From: [REDACTED]
To: [Hinckley SRFI](#)
Subject: Response to HNRFI additional information
Date: 04 February 2025 10:45:47

A summary of my feedback regarding the B4669 Hinckley Road/Leicester Road Sapcote issues is as follows:

A summary of my feedback regarding the proposed changes in the centre of Sapcote, surrounding the Co-Op is as follows:

Proposed Layout - 16.5m Max Legal Articulated Vehicle

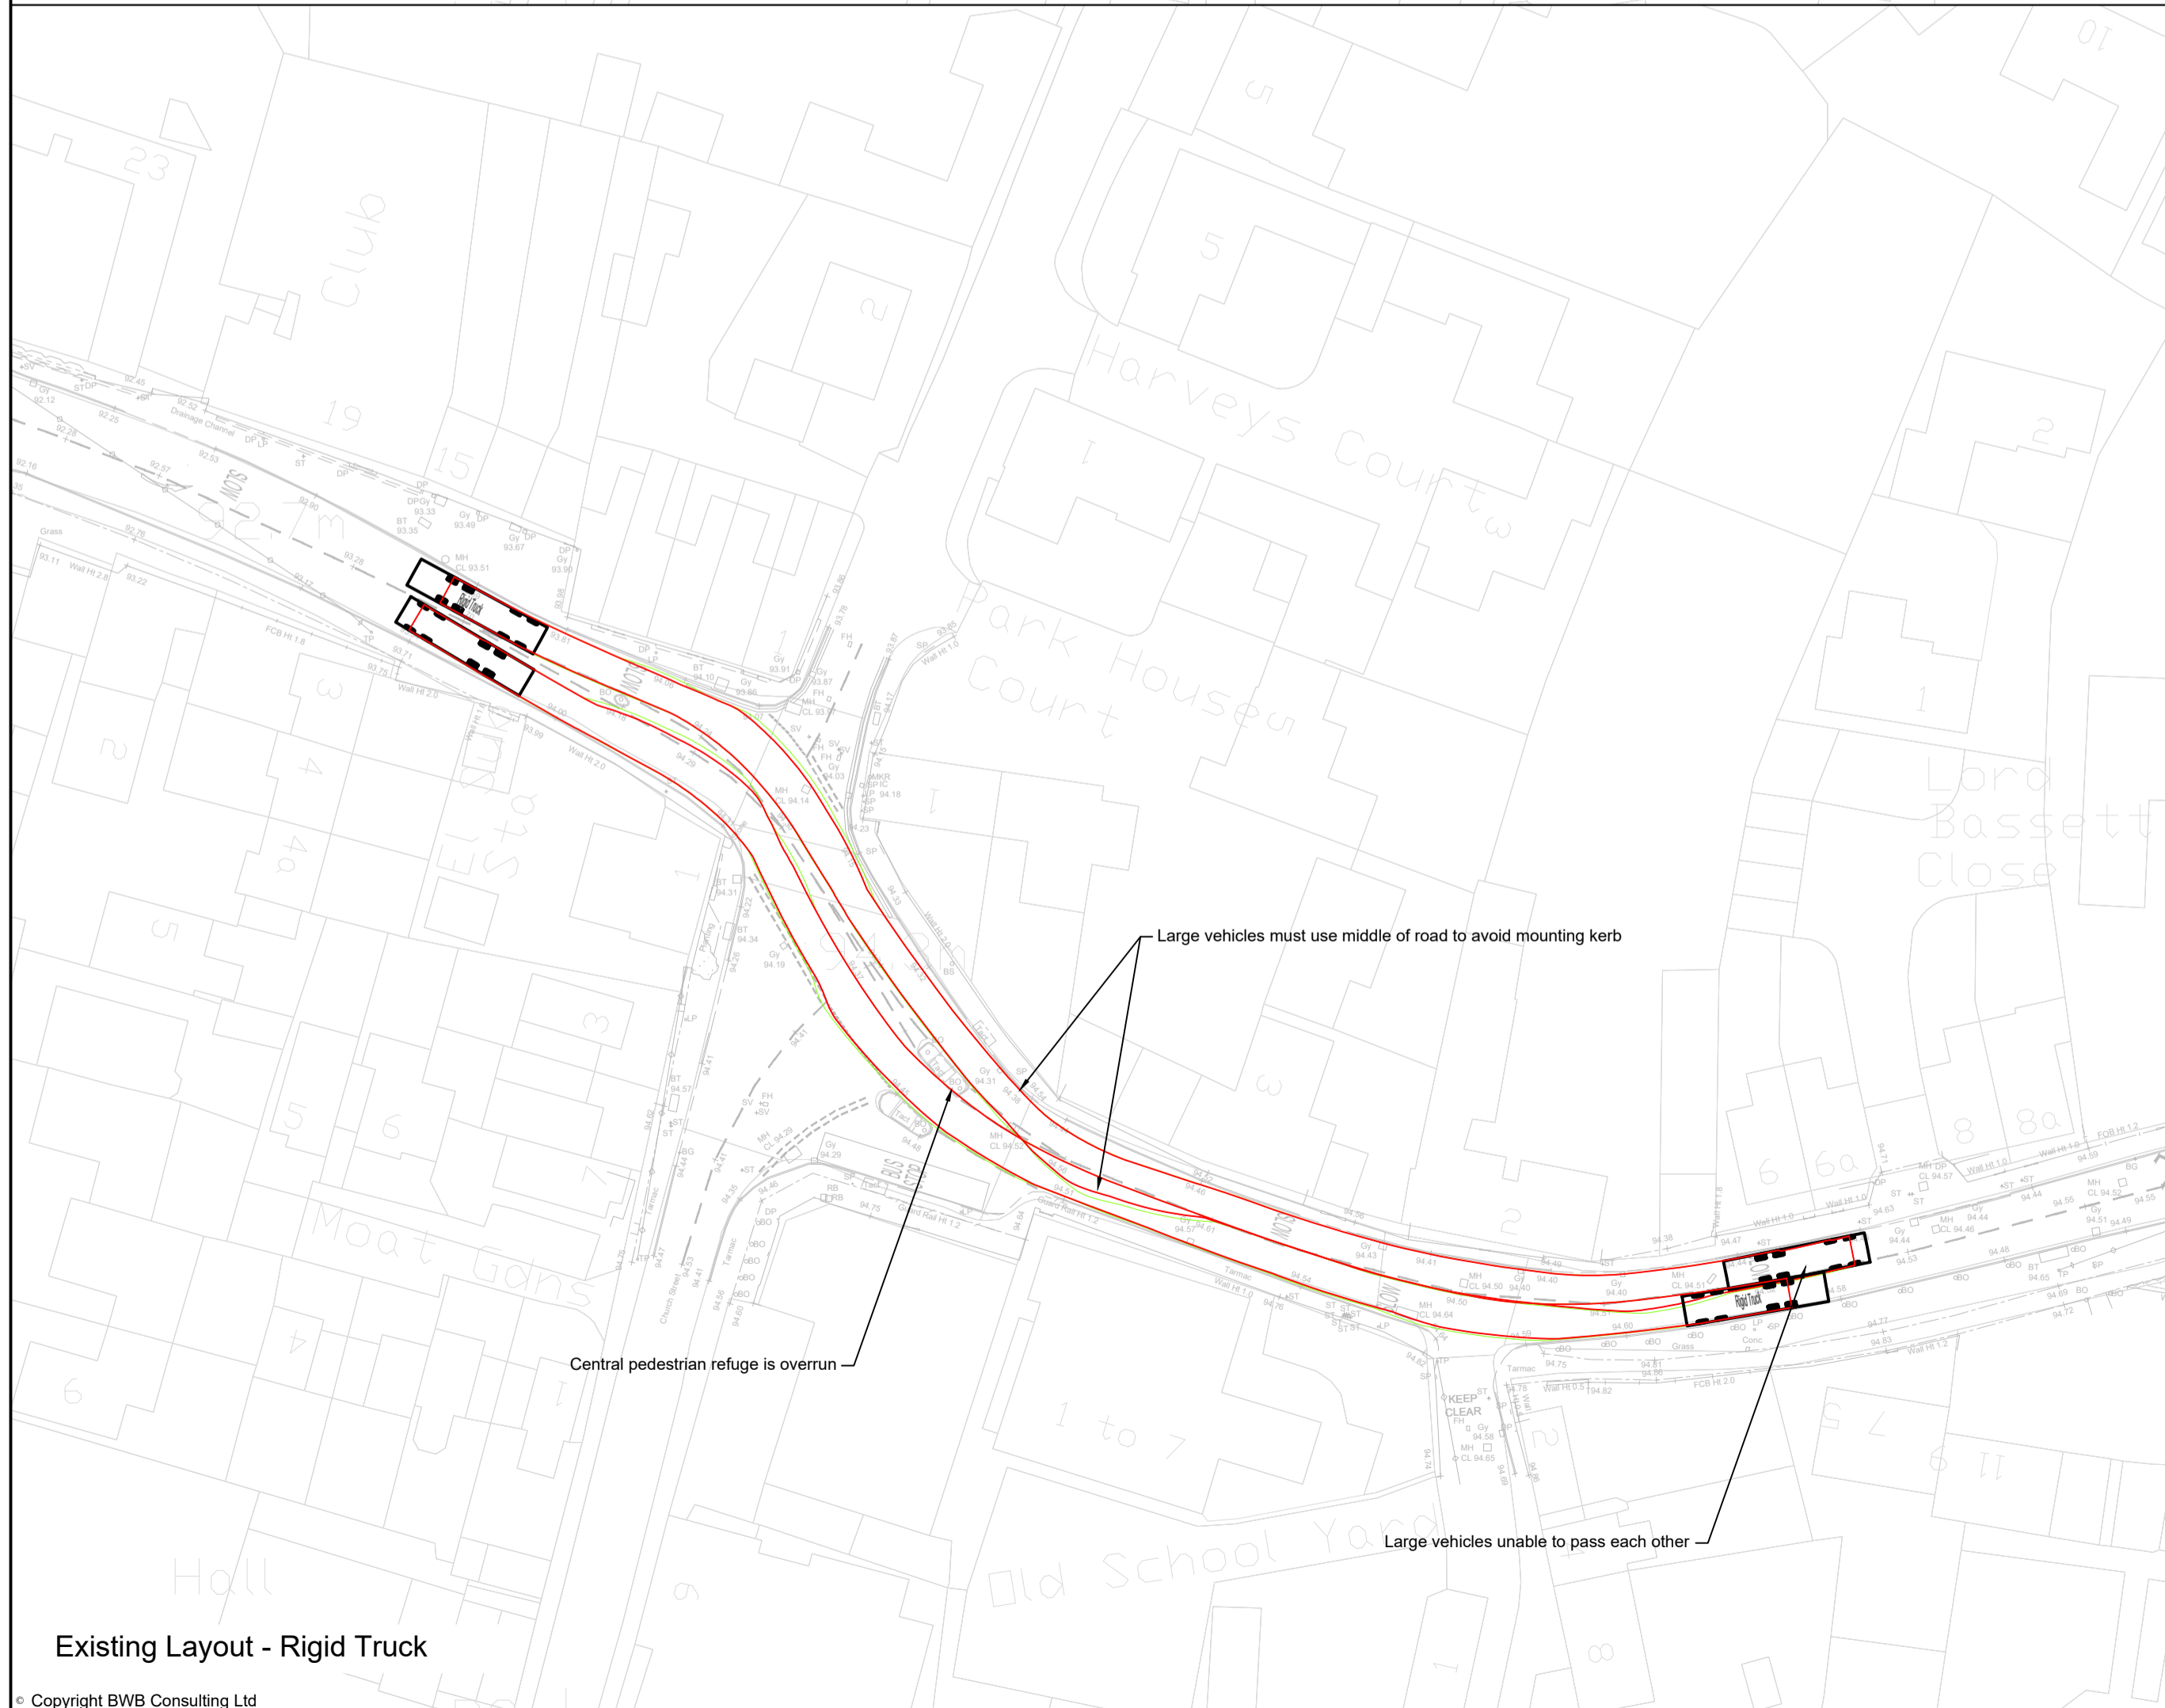
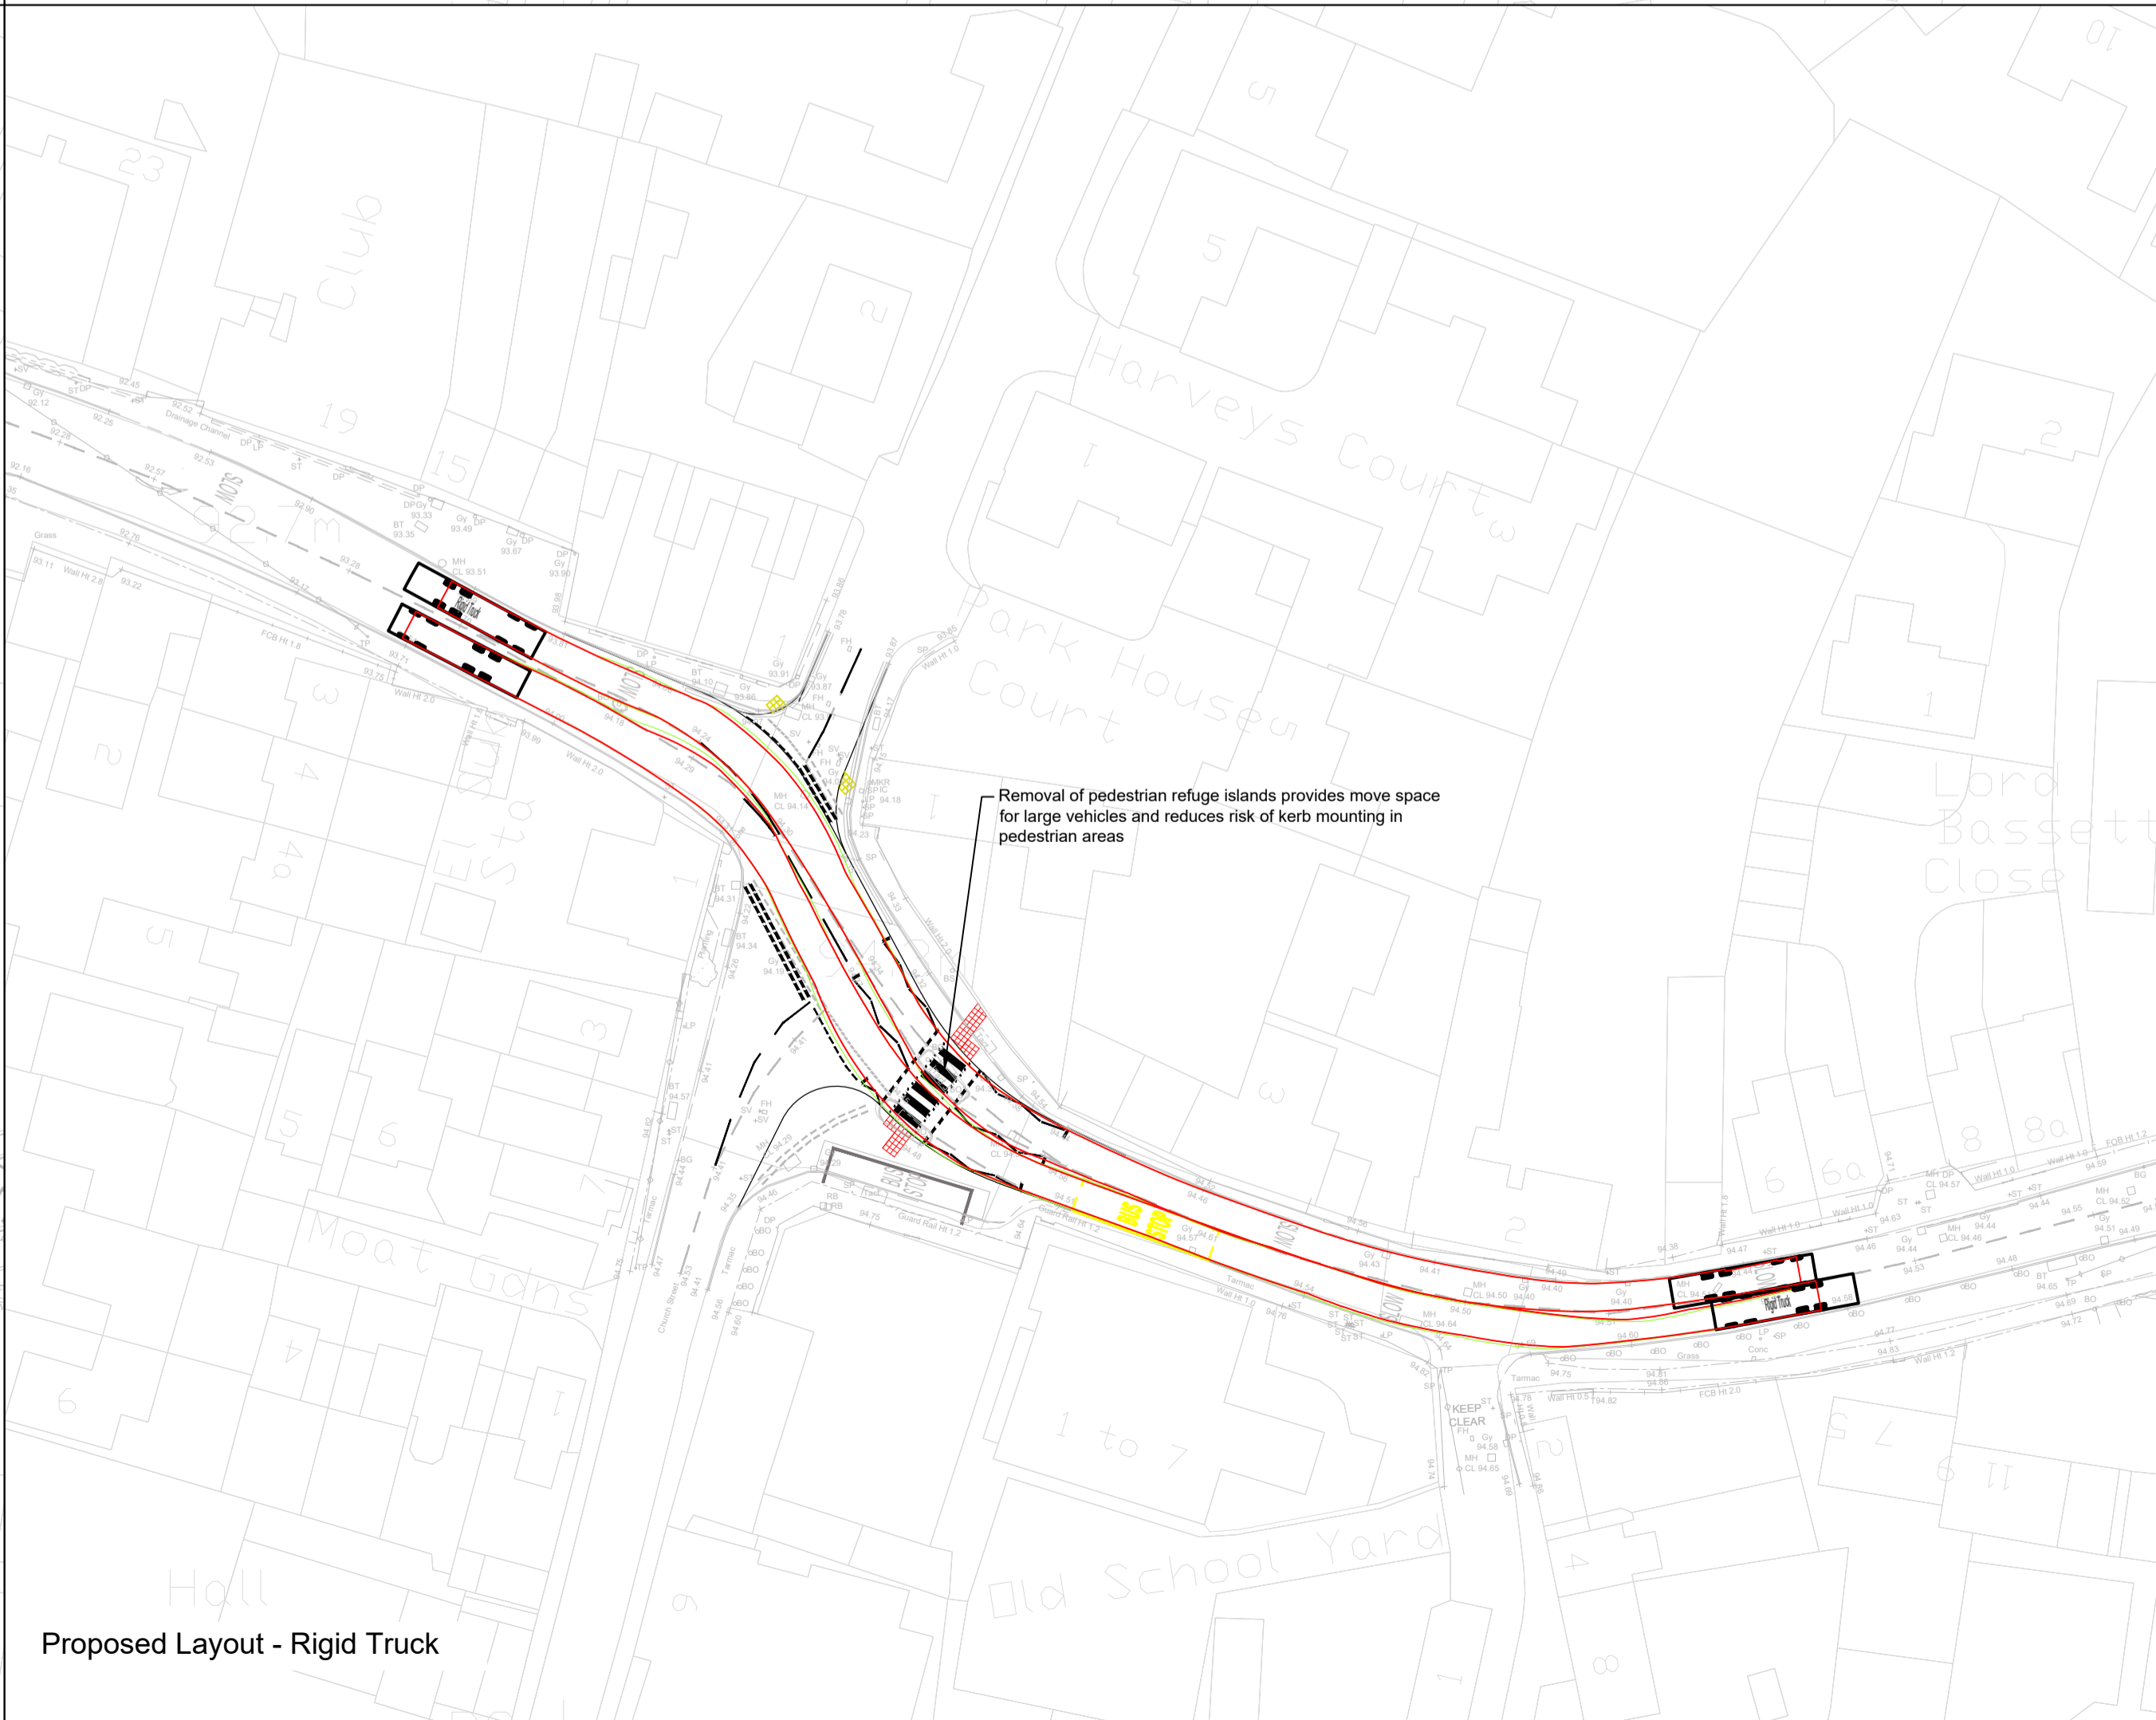
- Narrowing the Hinckley Road/Leicester Road to restrict the number of Lorries coming through Sapcote is poorly thought out. There is no provision for what happens when there are two oncoming vehicles in the narrow part of the road, or for which direction has priority. There is no room for vehicles to wait and this will force a vehicle onto the pavement to avoid a collision.
